Department of Primary Industries

OUT17/26949

Mixed Use Development, 50 Honeysuckle Drive, Newcastle (SSD 8019) Comment on the Environmental Impact Statement

BASEMENT GENERAL ARRANGEMENT PLAN - (ZONE 3)
SCALE 1 : 100

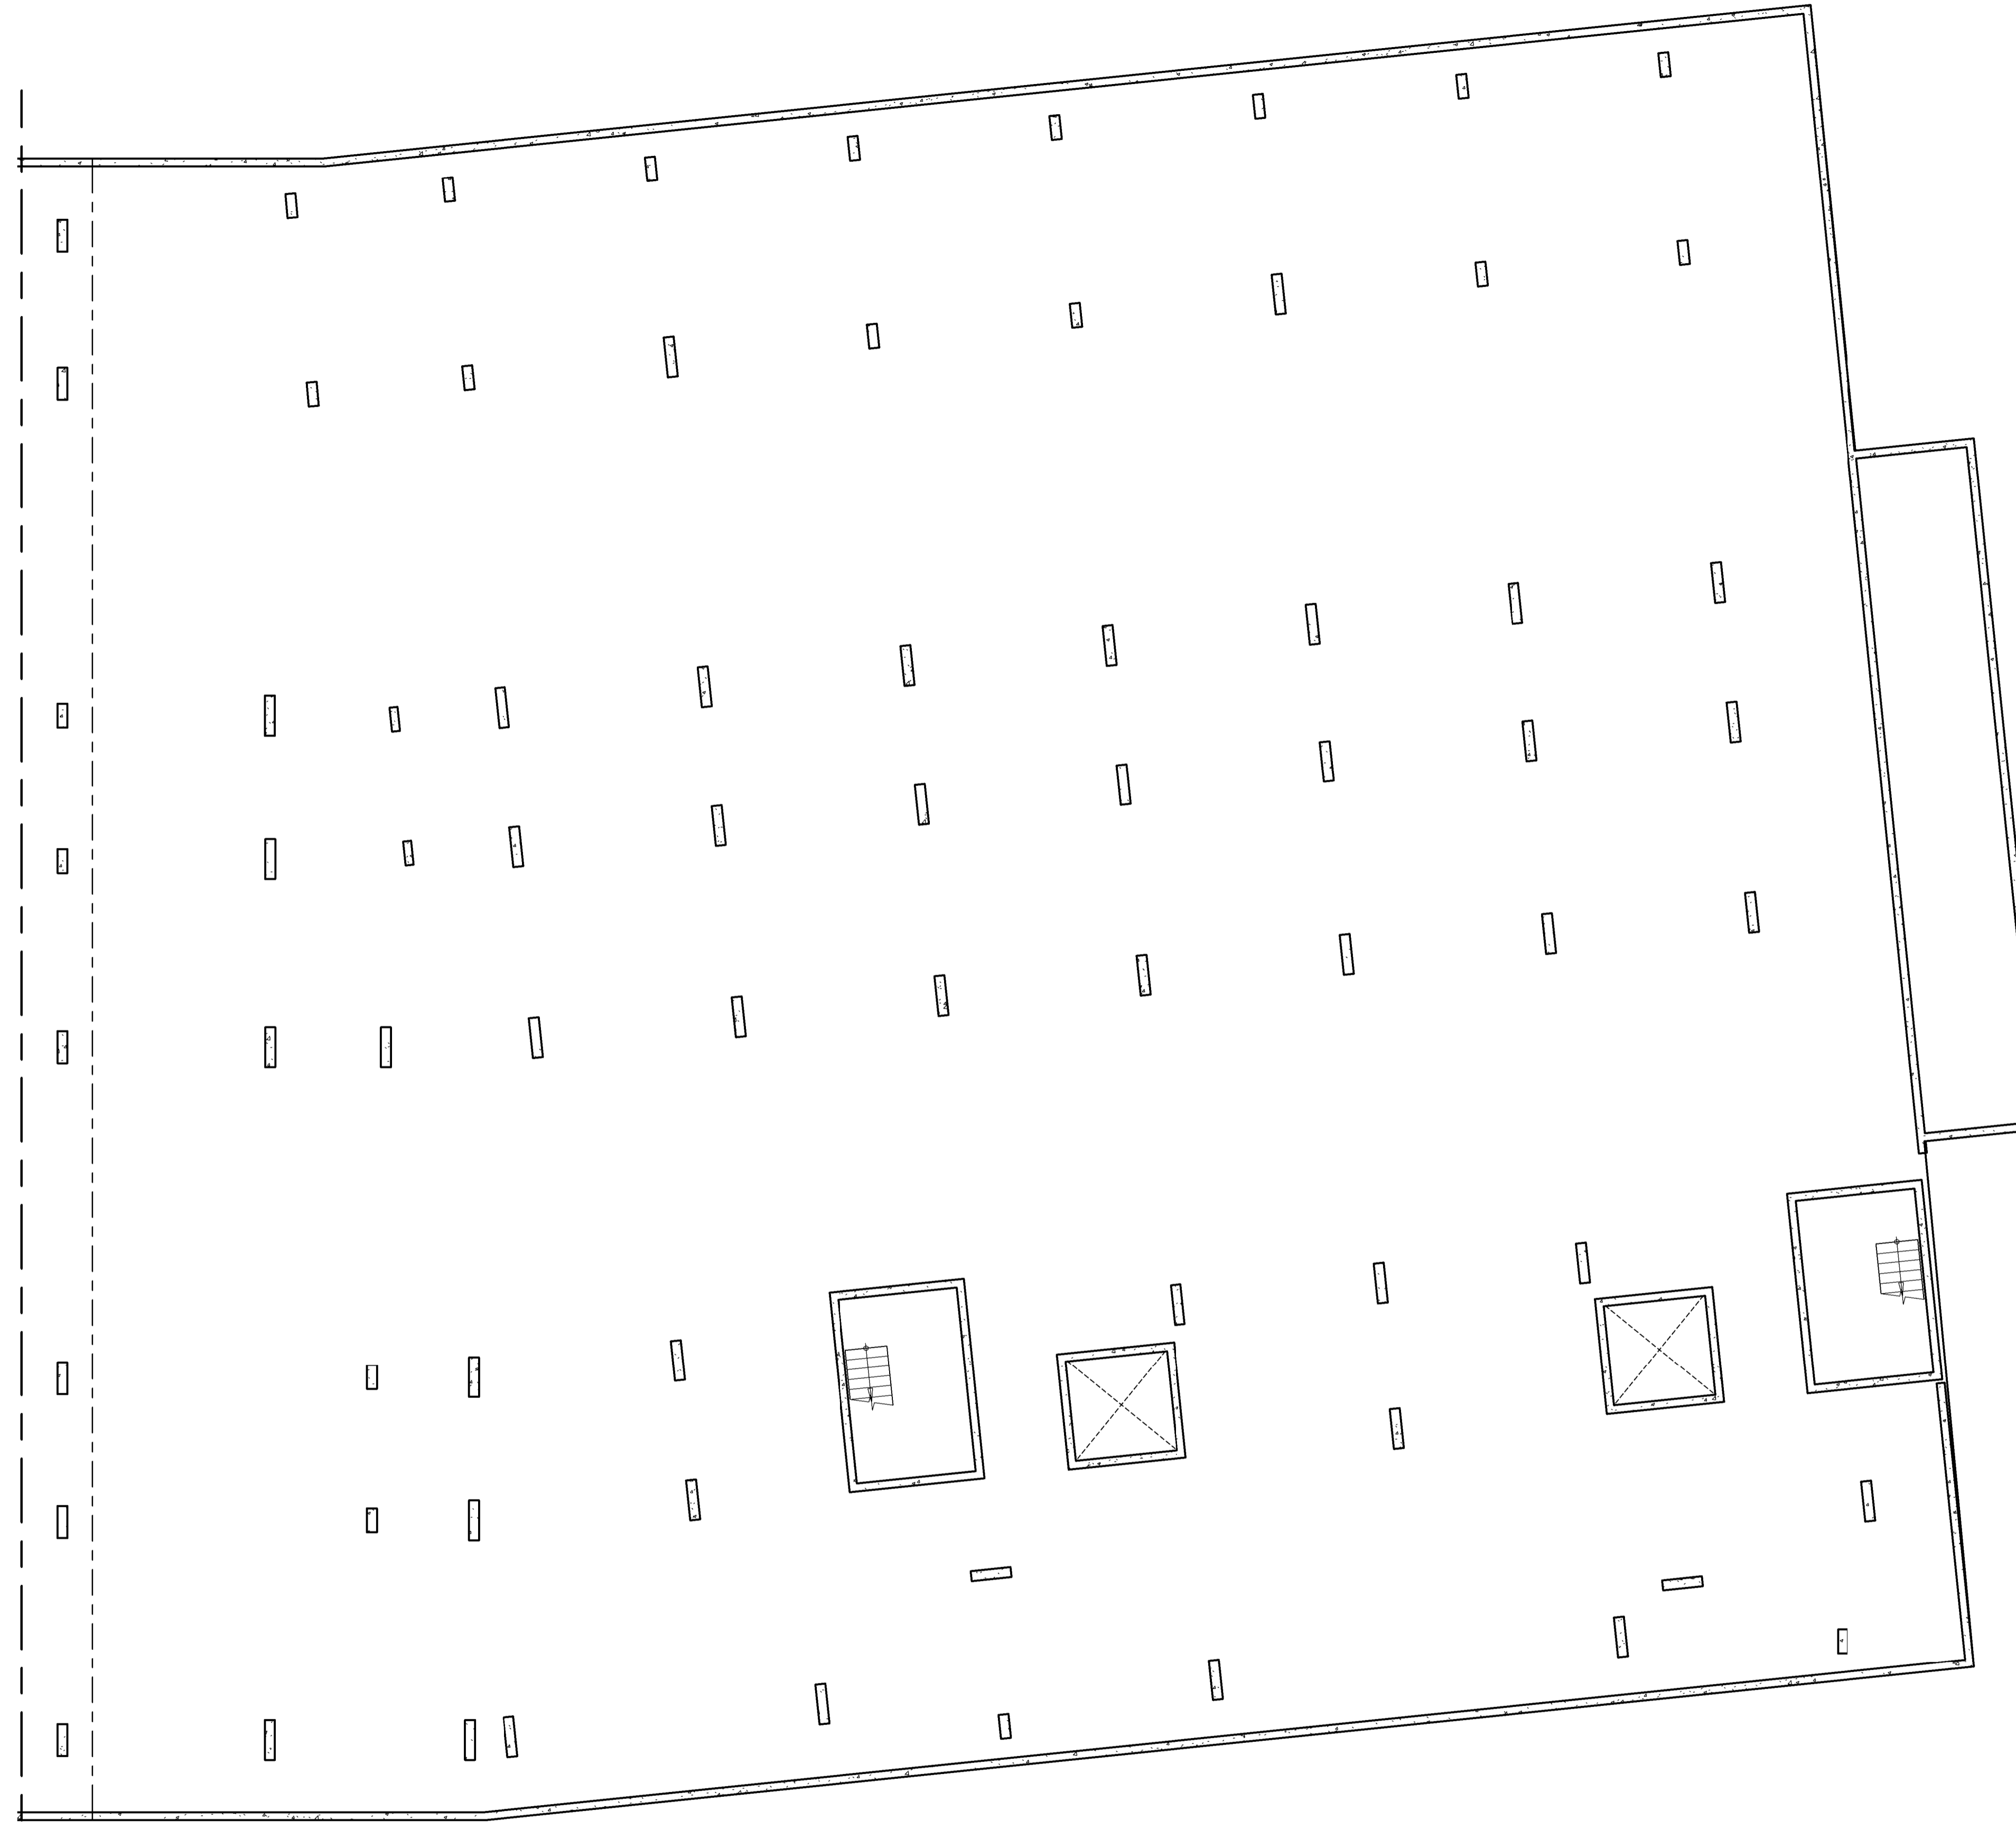
DPI does not consider that the SEARs have been adequately addressed as the extraction requirements of the construction dewatering have not been defined and there has been no assessment of the 'minimal impact considerations' of the NSW Aquifer Interference Policy (2012) (*the AIP*).

It is recommended that the proponent undertakes the above work and also provides the calculations used in estimating construction dewatering requirements. This is also important to ensure the waste water management plan is designed to ensure appropriate storage is available for extracted groundwater for retention times to facilitate optimal treatment of water quality prior

Further clarification is required regarding the proposed design of the basement carpark. DPI recommends the basement carpark be tanked (sealed) to prevent groundwater ingress. Any ongoing dewatering of the basement carpark will likely require a Water Access Licence from the Hawkesbury to Hunter Coastal Sands Groundwater Source.
